Your Reference: MP 10_0171 MOD 13

Re: 330 Church Street, Modification 13 to MP 10_0171 Mixed Use Residential Development

Thank you for the opportunity to comment on the proposal for the amendment of condition F9 to allow the implementation of an intercom access system at the residential entry and exit driveway.

Figure 2. The approximate location of the proposed modification is shown in the yellow circle (source: Near Map, February 2017).

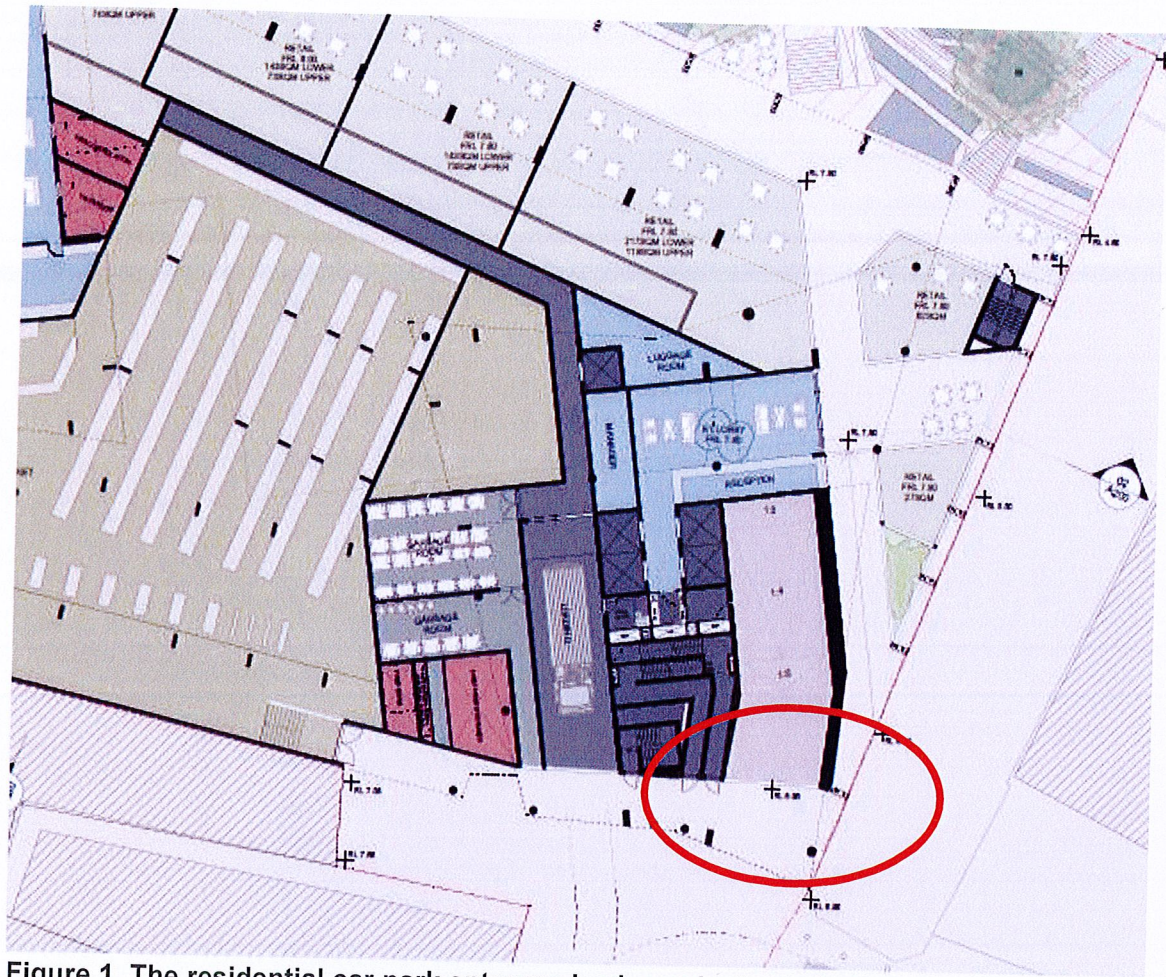
Council is concerned that amendment of the condition and the proposed configuration does not comply with the Australian Standard (AS2890.1.2004: Part 1 Off-Street Parking) for driveway width and the ramp grade of the control point.
